DECISION DELEGATED TO HEAD OF PLANNING

Application No: H18-0367-25 **Applicant:** Mr & Mrs J Cooper
Proposal: Residential Development of 2 dwellings - Outline Approval H18-0241-22
Location: Adjacent To Rylton House Mill Lane Sutton Bridge
Terminal Date: 10th June 2025

CASE OFFICER ASSESSMENT

PLOT 1 & 2  
FLOOR PLANS & ELEVATIONS

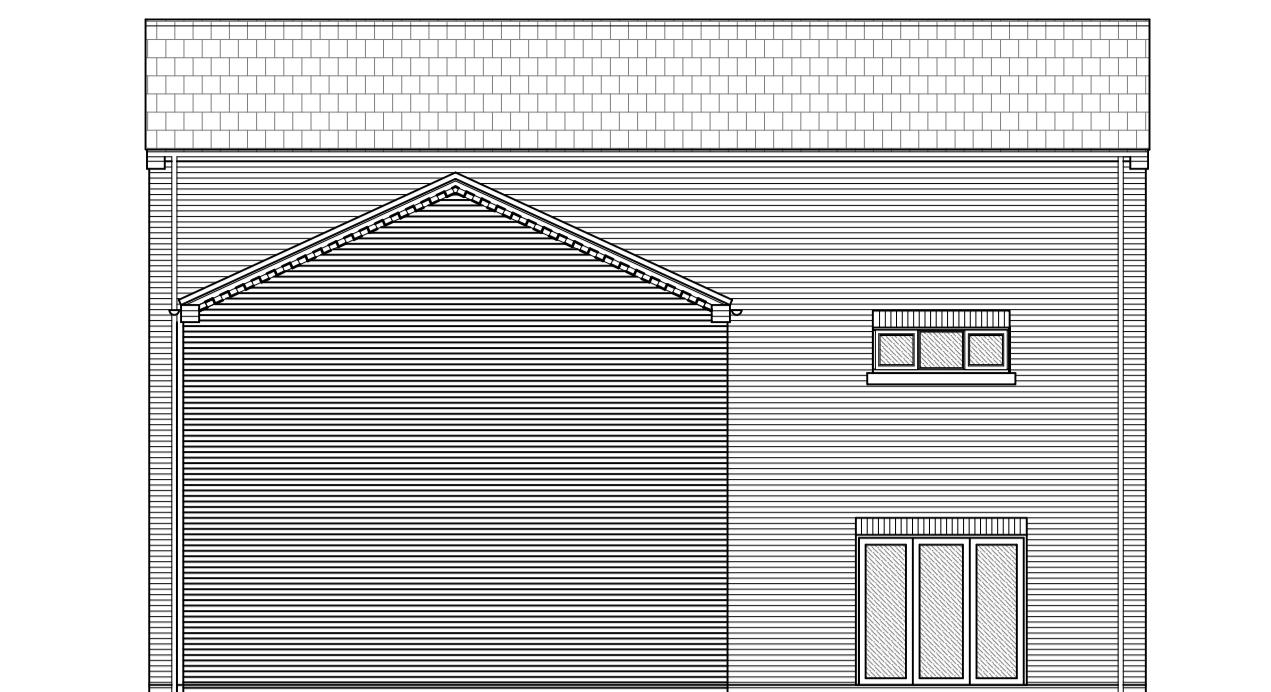
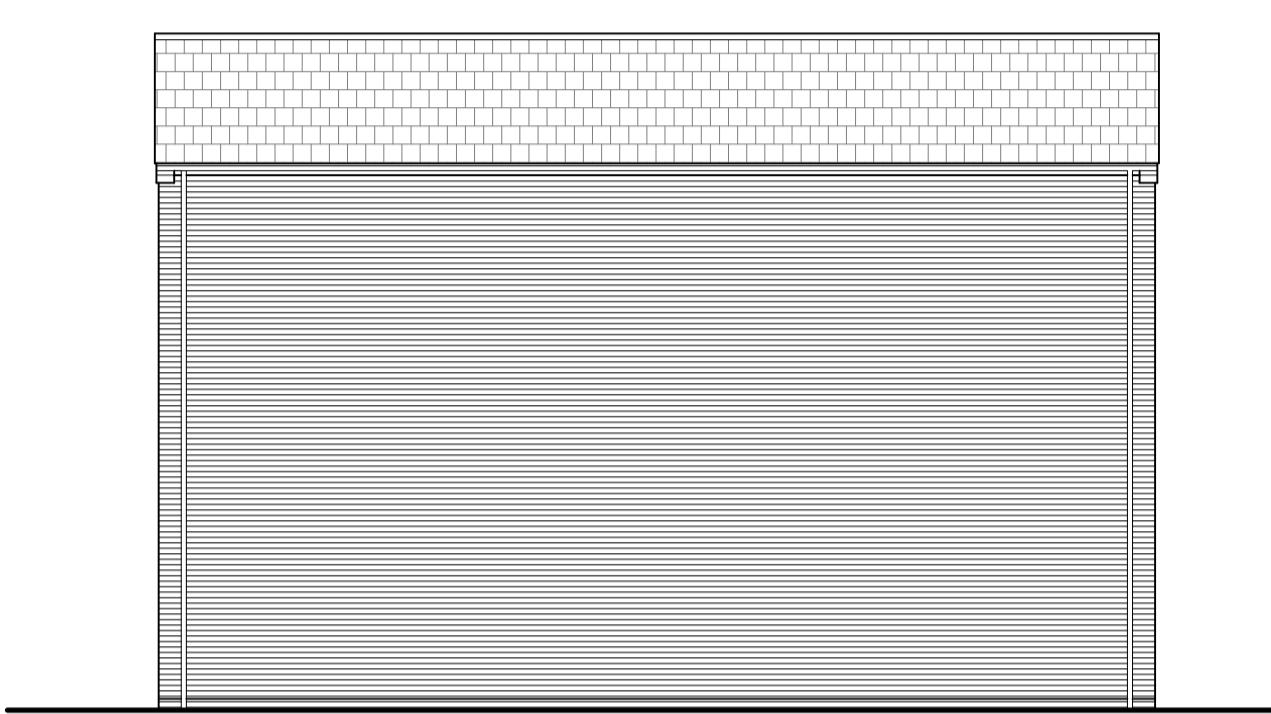
The proposal is for two 3-storey dwellings. The dwellings present a gable to the front and rear, both with two storey intersecting side wings that contain garaging on ground and bedroom above. The roof of the dwellings have a shallow pitch resulting in the eaves being very high. Both properties have a gable porch, two garage doors to the front (one to the rear) and a Juliet balcony also at the rear. There is fenestration on 3 number elevations.

The scale and massing of these dwellings is at odds with the existing character of the area and would result in two incongruous features, located centrally within Mill Land and abutting bungalow properties to their south and west. Whilst external materials are not made explicit; the scale, mass and general form/appearance of the properties would therefore be at odds with the local character.

Whilst openings may be appropriately located to minimise any visual intrusion (subject to the first-floor side opening being obscure), the scale and massing along with the proximity of 3-storey dwellings, sited next to bungalows would have an overshadowing and overbearing impact on neighbouring amenity. Properties on Nene Meadows would especially be overshadowed in both the rear amenity and rear elevation in the latter parts of the day.

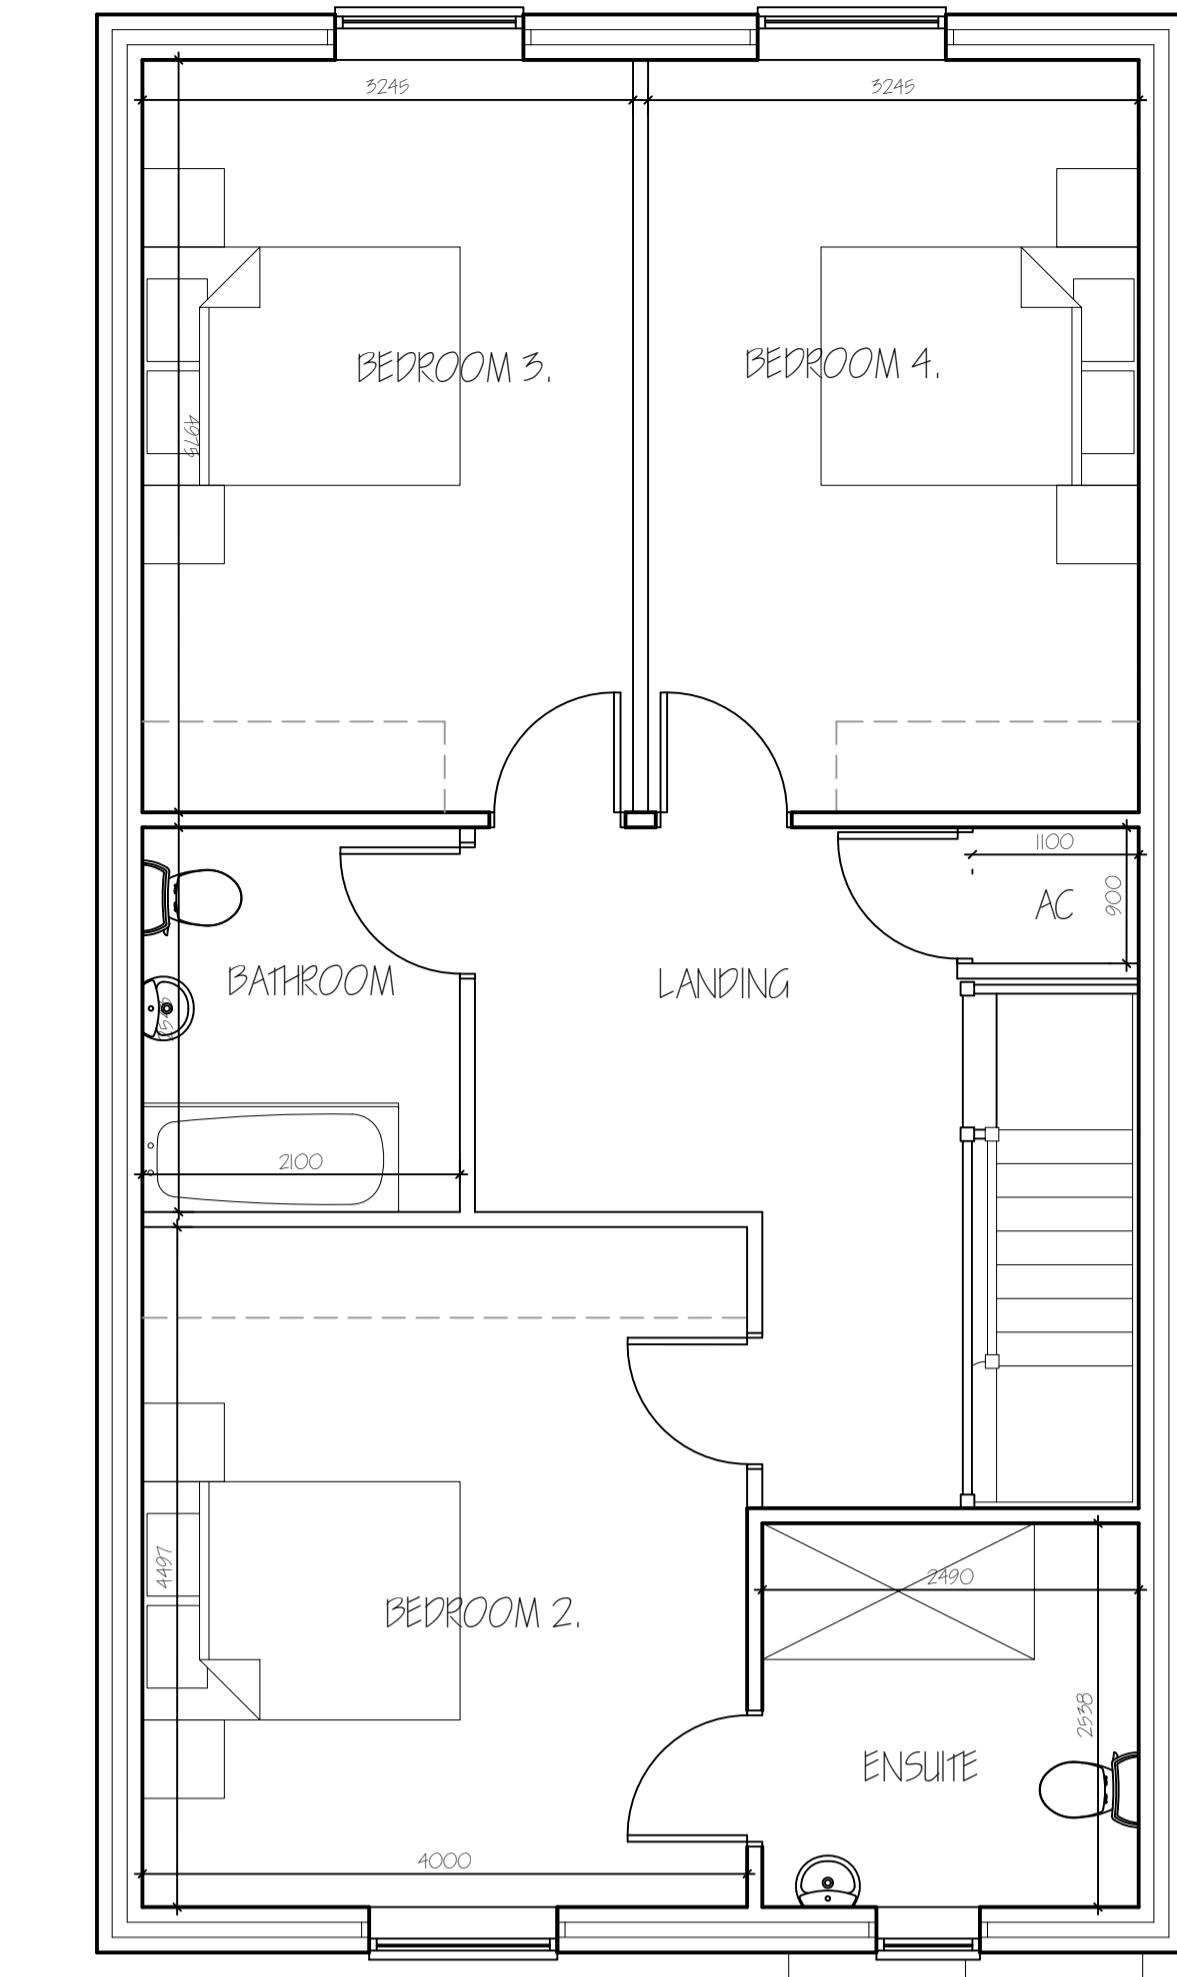
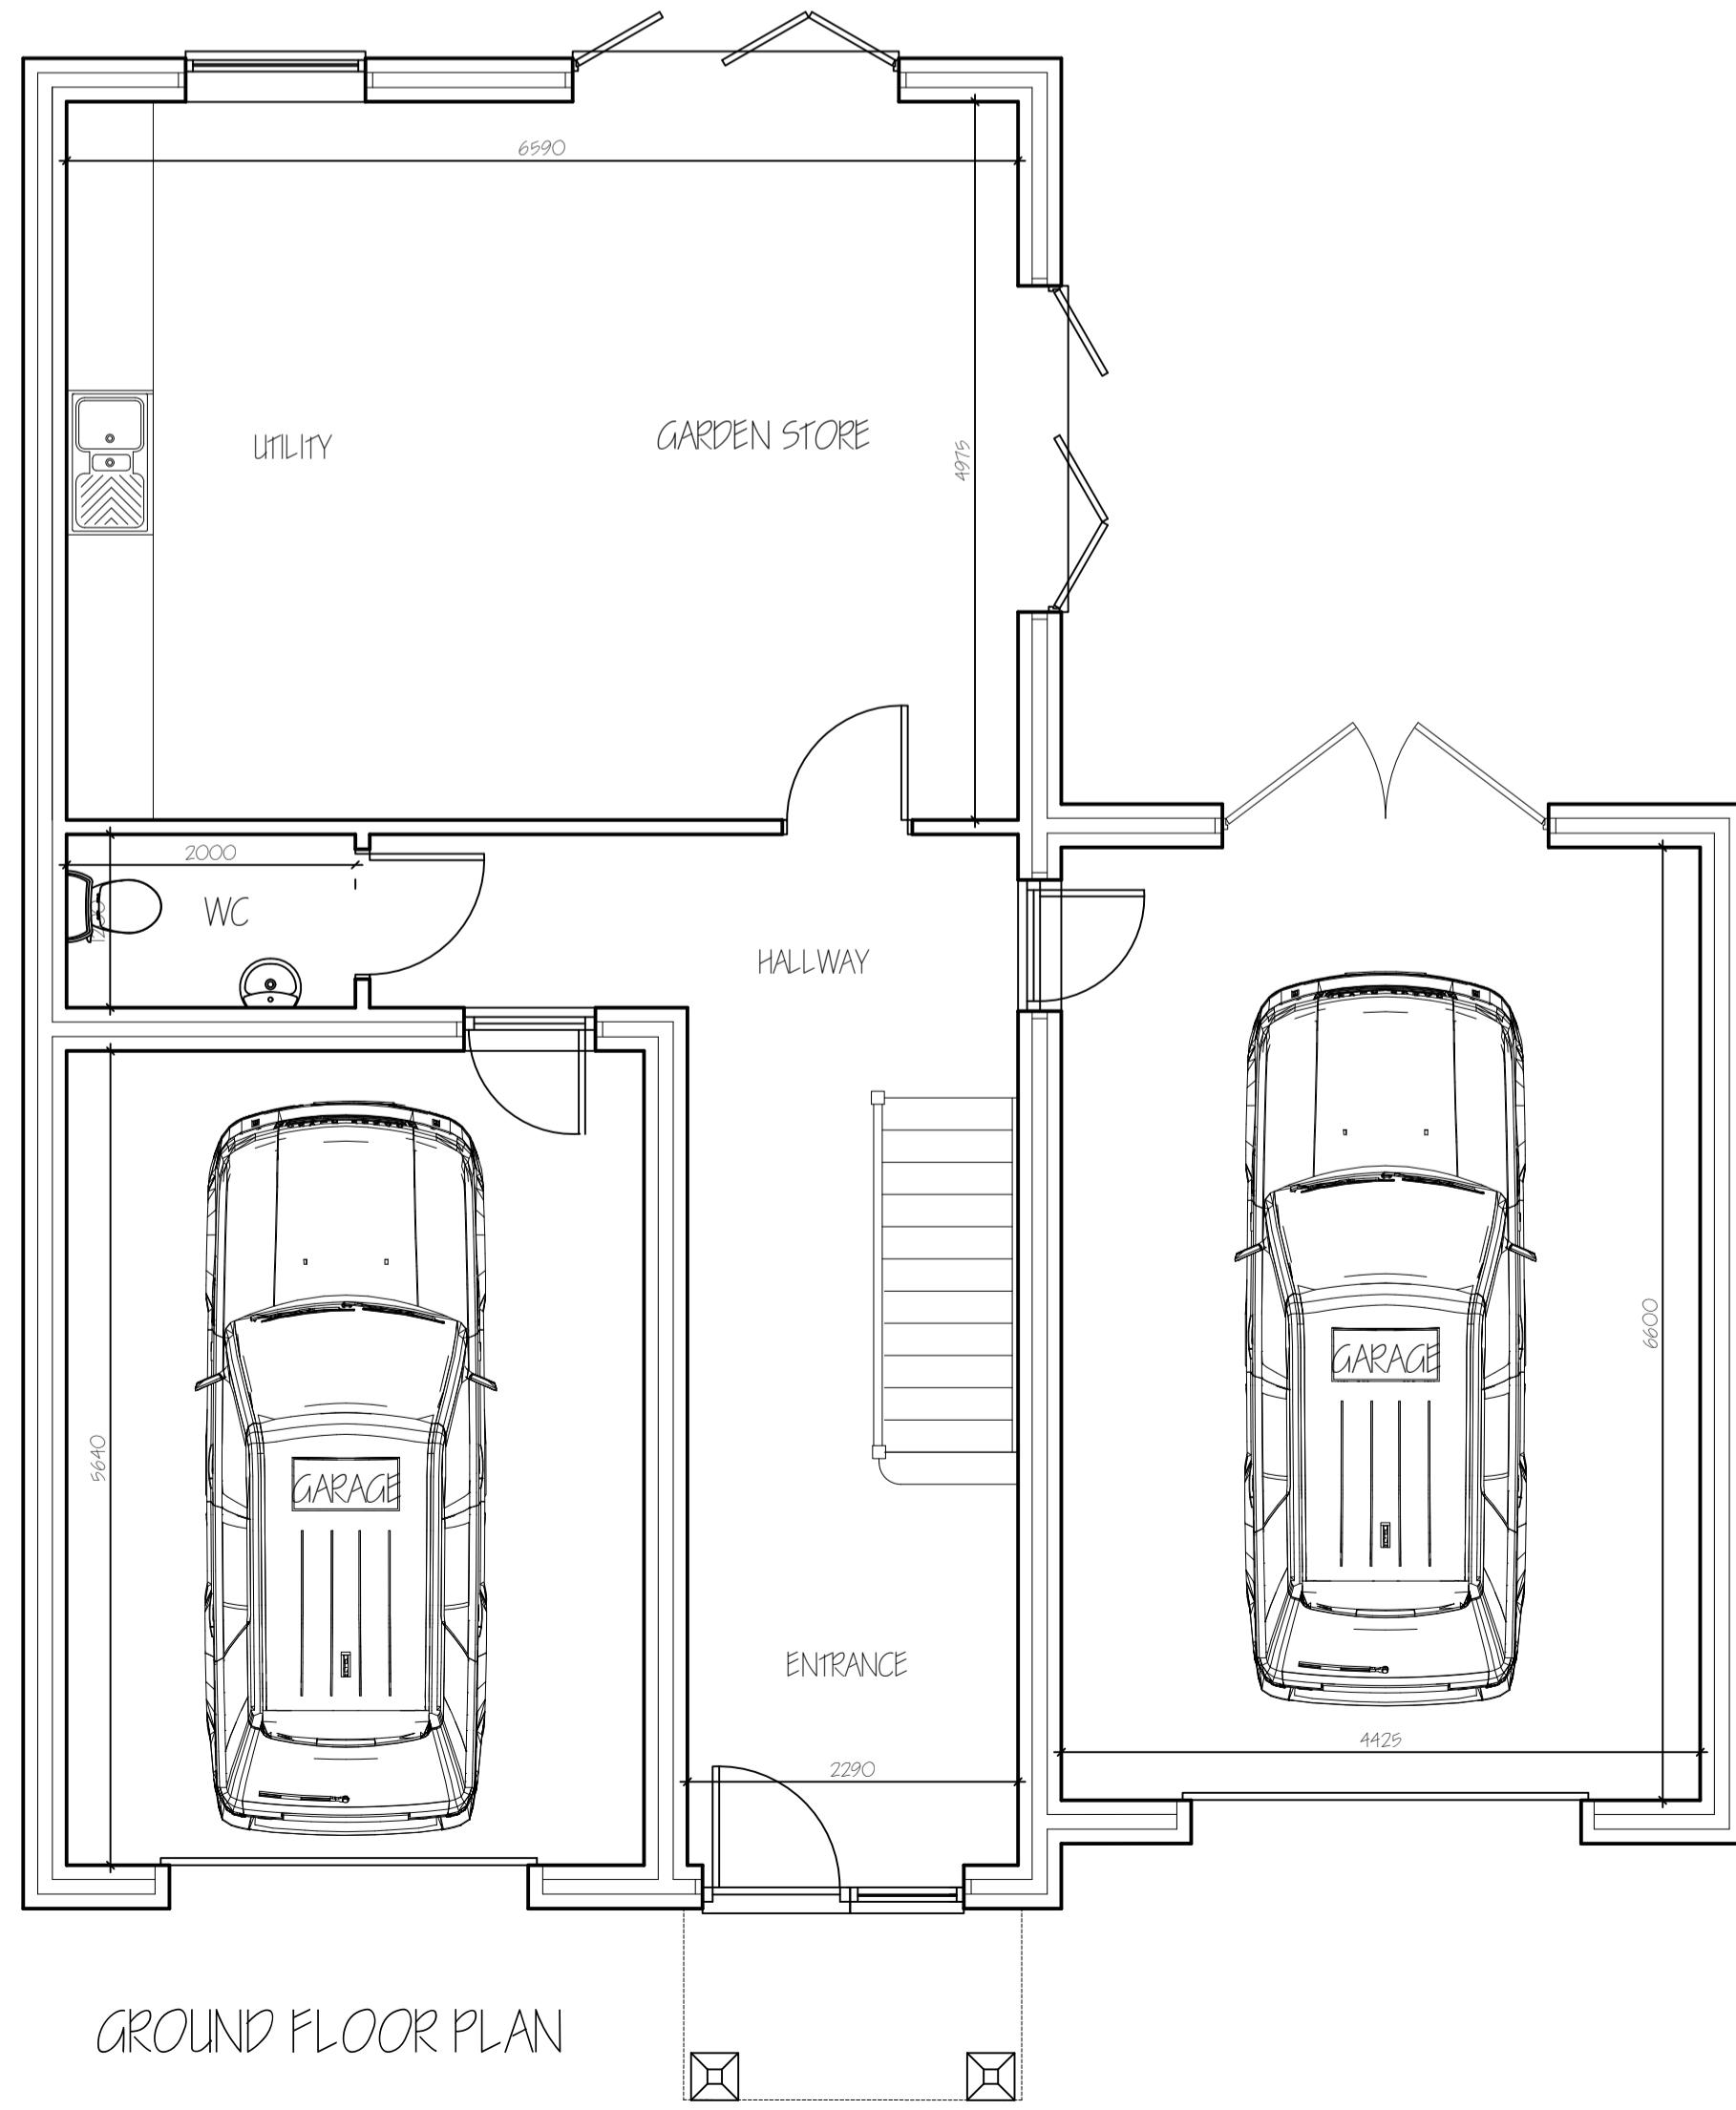
The scale of the dwellings is located across 3 floors, with garaging and utility at ground floor level, kitchen, lounge and master bedroom at first floor, and a further 3 bedrooms on the second floor. The proposed plans do not contain detailed information relating to external materials.
